**Re: Veterans Affairs National Cemetery
Traffic Impact Analysis (G06D001)**
Engineer's Stamp 5-21-24
Via email jlmlanovich@wellsandassociates.com

The subject Traffic Impact Study (Study) draft received on August 19, 2024, has been reviewed by the City of Albuquerque Planning Development Transportation Section. Jurisdiction of Atrisco Vista Blvd is under the City of Albuquerque. The City has the following comments to be addressed.

ATRISCO VISTA BOULEVARD ROAD IMPROVEMENT PLANS

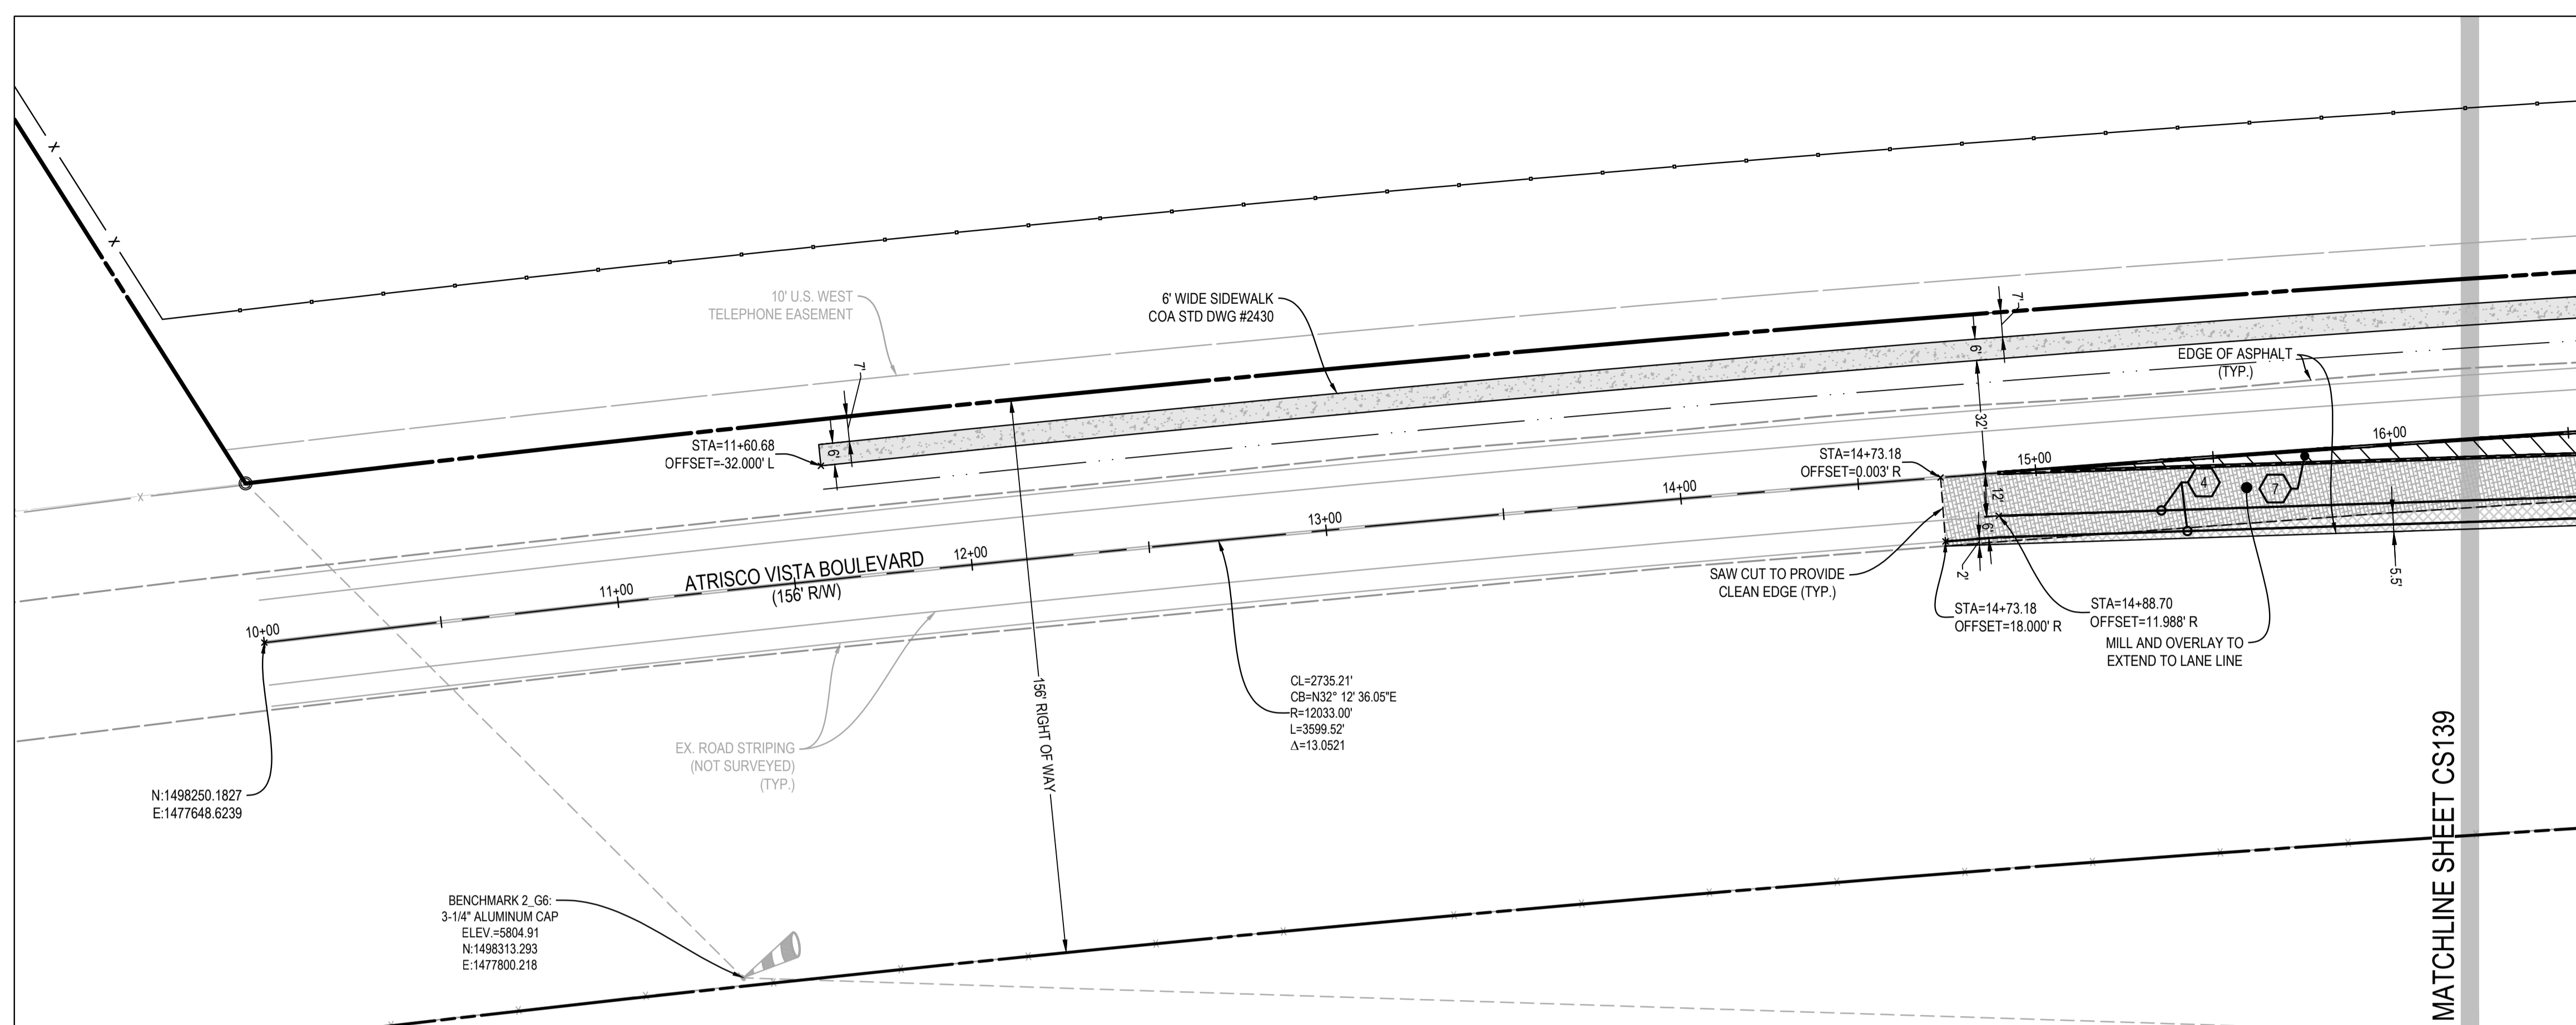
3. How far is the proposed main driveway from the end of the acceleration lane south of Shooting Range Rd?
4. The Conceptual Site plan shows the gate on Atrisco Vista Blvd in the ROW. It should be moved back to the property line or further, in case the City needs to widen the roadway.

5. The city concurs with the 300-foot left turn lane on northbound Atrisco Vista Blvd at the main entrance, however, per the DPM the transition is a 150-foot reverse curve.

SHOOTING RANGE ROAD ENTRANCE PLANS

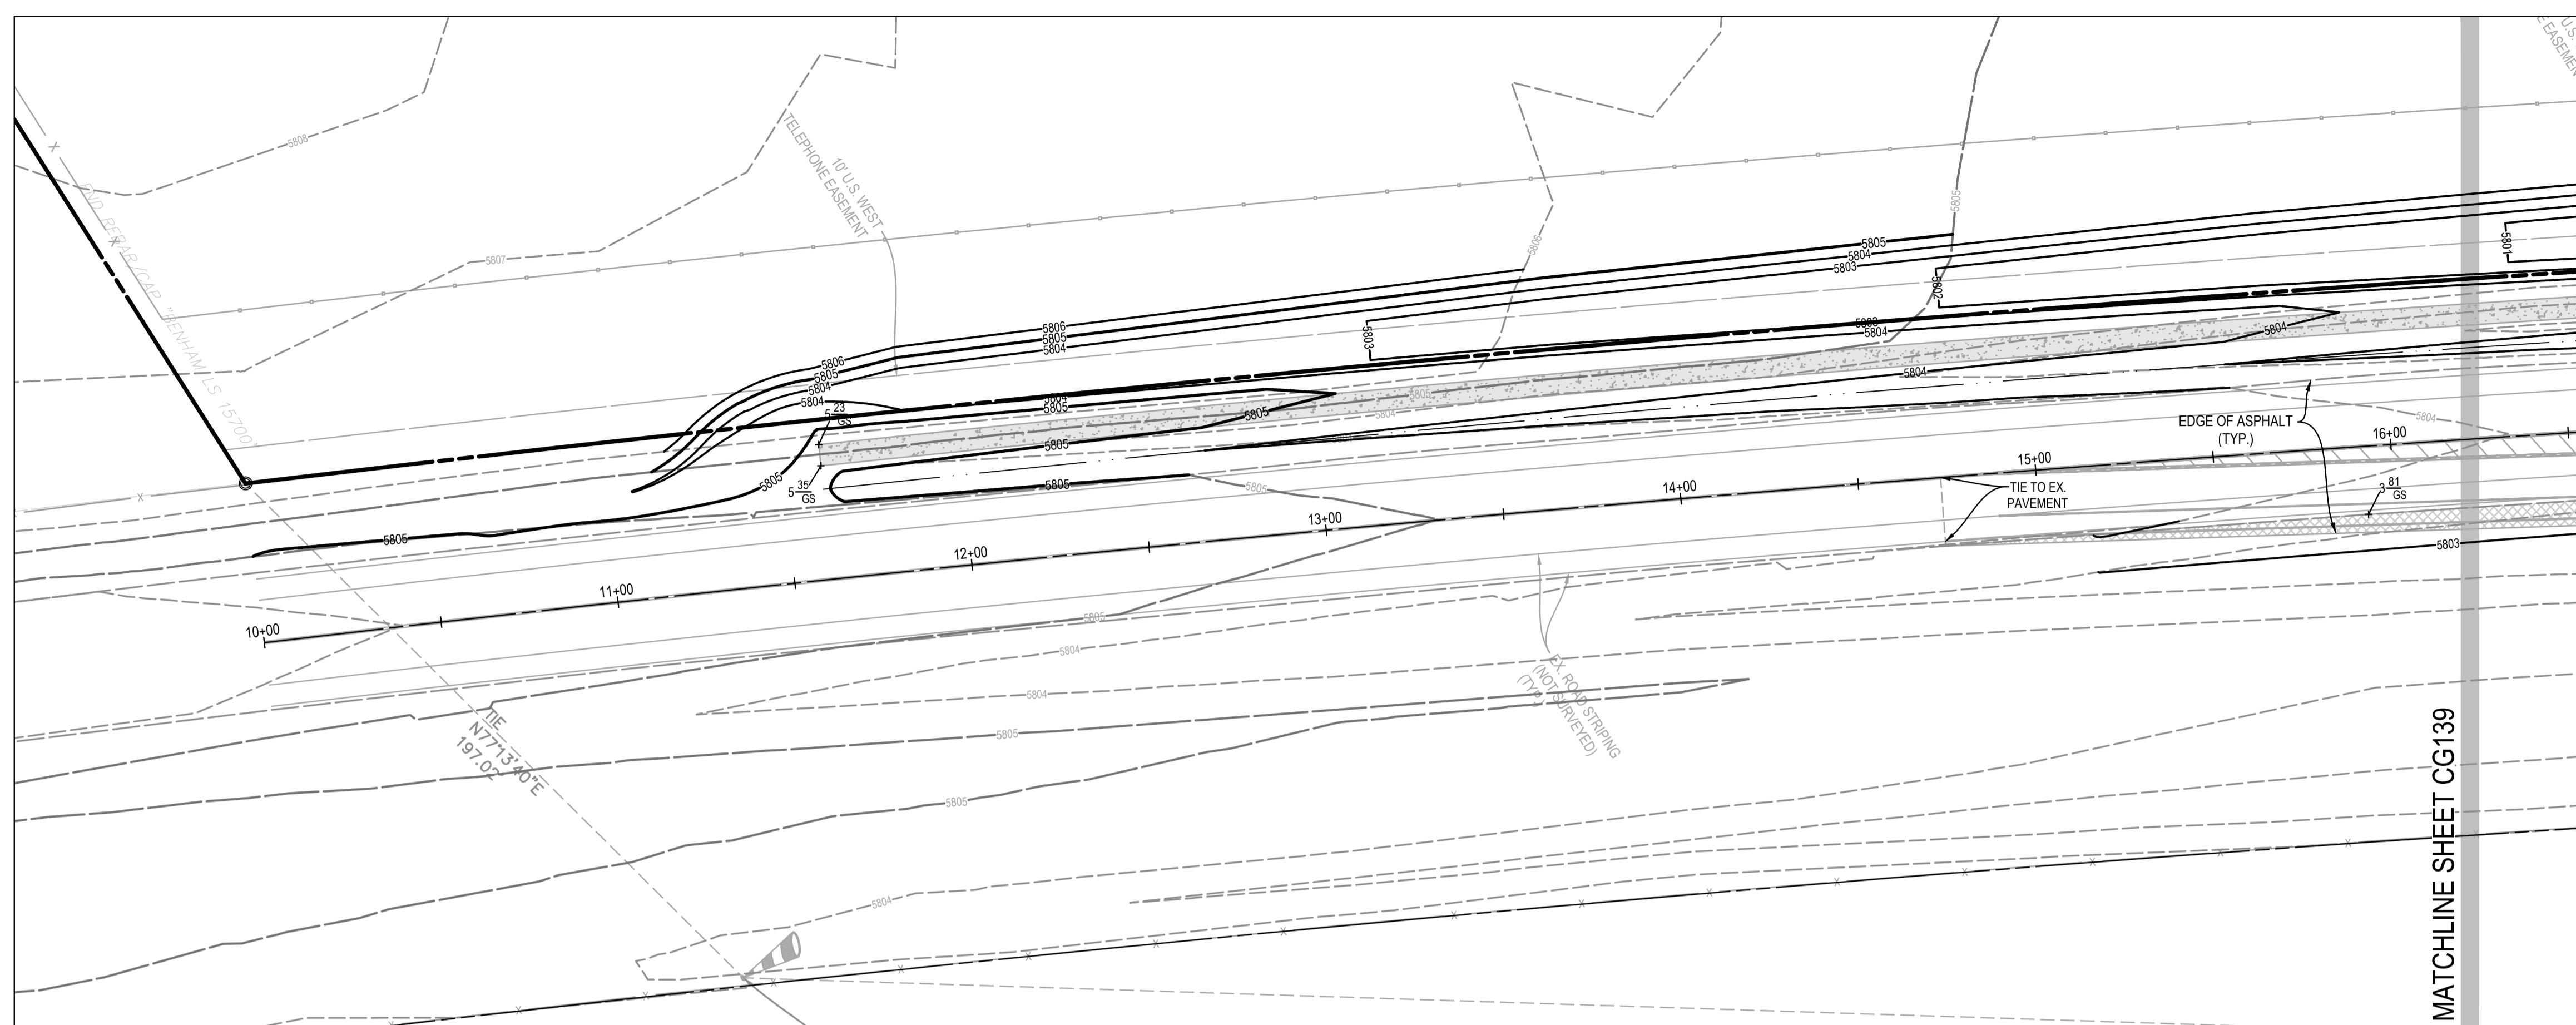
6. To minimize conflict points, it is preferable to only have one driveway on Shooting Range Road. It appears the location of "Service Entrance" on the Conceptual Site Map is directly across the road from Aerospace Pkwy, which is an acceptable location.
